Engineers Comments Regarding Surface Water Drainage

Application Reference:	Y/37/25/DOC	Reviewer Reference:	ADC/EXT4
Planning Officer:	Hebe Smith	Date of Review:	14/11/2025
Site Name:	18 West View Drive Yapton BN18 0JR		
Application Description:	Approval of details reserved by condition imposed under reference Y/56/24/HH relating to condition number 3 - surface water drainage scheme.		
Assessment Number:	2 of 2

Application Reference: Y/37/25/DOC
Site Name: 18 West View Drive Yapton BN18 0JR

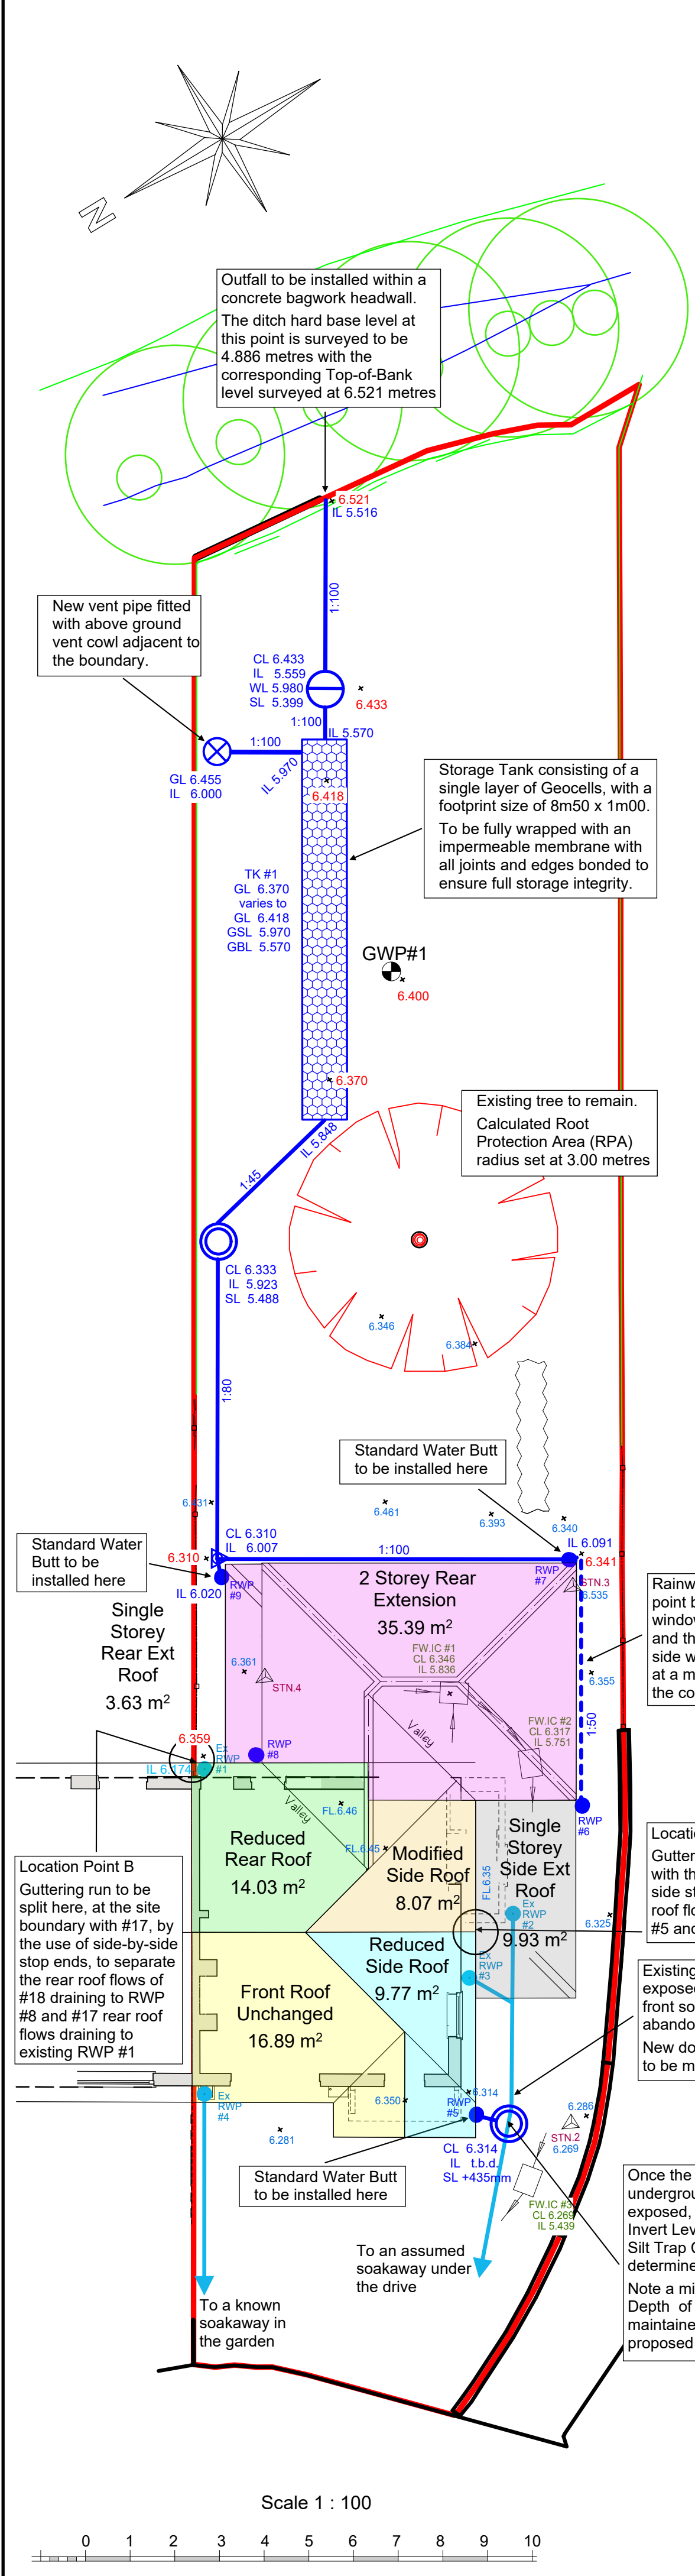
Plans	Plan areas, depths and levels of drainage infrastructure must accurately correspond with the supporting calculations.	Insufficient

Comment Number					
1.	Front roof areas noted to drain to an "assumed" soakaway. This needs to be investigated further and onsite assessment through testing to confirm that the existing soakaways can cater for the peak design storm events if looking to reuse.	This is assuming that you don't mean the actual Front Roof which is Unchanged going to a known front soakaway. The assumed front soakaway under the drive drains flows from the existing main side roof and the existing side lean-to roof for a total of 20.2 m2 . The proposed reduced existing side roof area of 9.77 m2 drain as existing to this soakaway. This is over a 50% reduction of flow from re-aligned roof. Betterment is also provided by the installation of a new Silt Trap. As this remains as existing, with a significant reduction in flow, no additional investigations or assessments were required. The single storey side extension now with an increased roof area to 9.93m2 drains with RWP down and across the side wall, under the window, but crucially above ground level, with a minimum fall of 1:50, to be connected to RWP#7 at the rear. New calculations determine an increase to the tank TK#1 to 8.5 metres long. The layout and constructional drawings plus the calculations have all been updated to Revision 03 to reflect this change to the design. The only other practicable option is to run all the roof areas to the rear storage tank TK#1 however this will obviate the removal of the existing rear roof area from the Foul. Removal of the Foul Water flows is not mandatory as regards planning (since it is existing) but is always Best Practice – especially within the Lidsey Catchment Area.	It is understood that the designer is attempting to demonstrate that flood risk will not be increased due to a reduction in the areas to the existing soakaway. However, the matter is that the development proposals are seeking to re-use an existing soakaway for a new extension over the lifetime of the development without knowledge on the location, size, condition and performance of this soakaway, knowing that groundwater levels are high enough in the rear garden to rule out infiltration. Evidence needs to be provided on the existence of this soakaway, location, size, depth as well as to undertake tests to ensure that it will perform to meet the lifetime of the development. If groundwater levels are expected to be different in the front garden to the rear, then evidence to support this assumption should be submitted. Alternatively, a new drainage solution may be submitted for the extension. Existing roof areas, where drainage arrangements are unchanged need not be included in this design solution. However, we support any improvement to the existing surface water drainage of those areas.

2.	The current drainage layout, includes several assumptions and caveats due to unknown level information. Some of	The front Silt Trap now has a note for its Invert Level (IL) to be determined when	These investigations should be determined prior to main works. These are critical to ensure that the drainage

these are critical to the function of the proposed surface water drainage and thus need to be investigated and confirmed	construction begins and excavation of the existing underground pipe establishes its depth, otherwise the pipe will have to be exposed / surveyed / re-instated prior to future commencement. The Sump Depth will have to be a minimum of 435mm below IL. All other 'tbc' have been surveyed inserted on the layout drawing which has been updated to Revision 03	solution being proposed for the discharge of condition are actually deliverable.

4.	The depth of drainage at the rear elevation appears too shallow, with inadequate cover to the pipework. Further details should be provided on this arrangement and potentially re-look at the gradient and depth of pipework leading back from the attenuation tank	Building regulations Approved Document H do not state a minimum cover depth for underground domestic rainwater pipes. The cover at RWP#7 is ~150mm and at the IC at RWP#9 is 198mm. Like all the pipework, the section at the rear elevation falls within Class Z and as such is subject to 150mm concrete bed & surround which will prove to be satisfactory for the non-vehicular soft landscaped garden area.	This is unacceptable. The proposals infer having concrete protection surround being exposed at the heads of the runs. This is giving rise to future failure of the pipework with such reduced cover. Should the proposal seek to maintain near or at surfaces depths of cover then detailed calculations should be provided to confirm the resistance to the proposed loads and maintaining the structural integrity of the pipework, with the nominal concrete surround should be provided. Should the pipework get damaged or deformed due to inadequate cover this will impact the ability of the pipework to convey flows and could cause flooding within the property.

5.	Please provide clarification on how the surcharge outfall has been modelled.	There was no hydraulic modelling data available from the EA to support a surcharged outfall thus the fall-back is that as per Arun DC statement of . . . where no appropriate Hydraulic Modelling for the surcharge level of the 1% AEP + CCA flood event for the receiving watercourse, then the Top-of-Bank level is the fallback . . . In this instance there will be no flooding within the site, as discussed within the Surface Water Drainage Statement and Design Notes Page #9 -- The Headwall	The response does not provide clarification on how run off from the roof's entering the system will be accommodated during a potential surcharged event within the watercourse. Whilst the bank level is noted and reference is made to the system being entirely surcharged and not above the proposed cover levels, the justification provided does not clarification on what will happen when water enters the same surcharged network. This needs to be modelled

and the Ditch. This was confirmed with consultation from the Principal Drainage Engineer (PC) Arun DC on 2nd September 2025	and assessment provided with updated calculations		
--	--	---	---	--	--
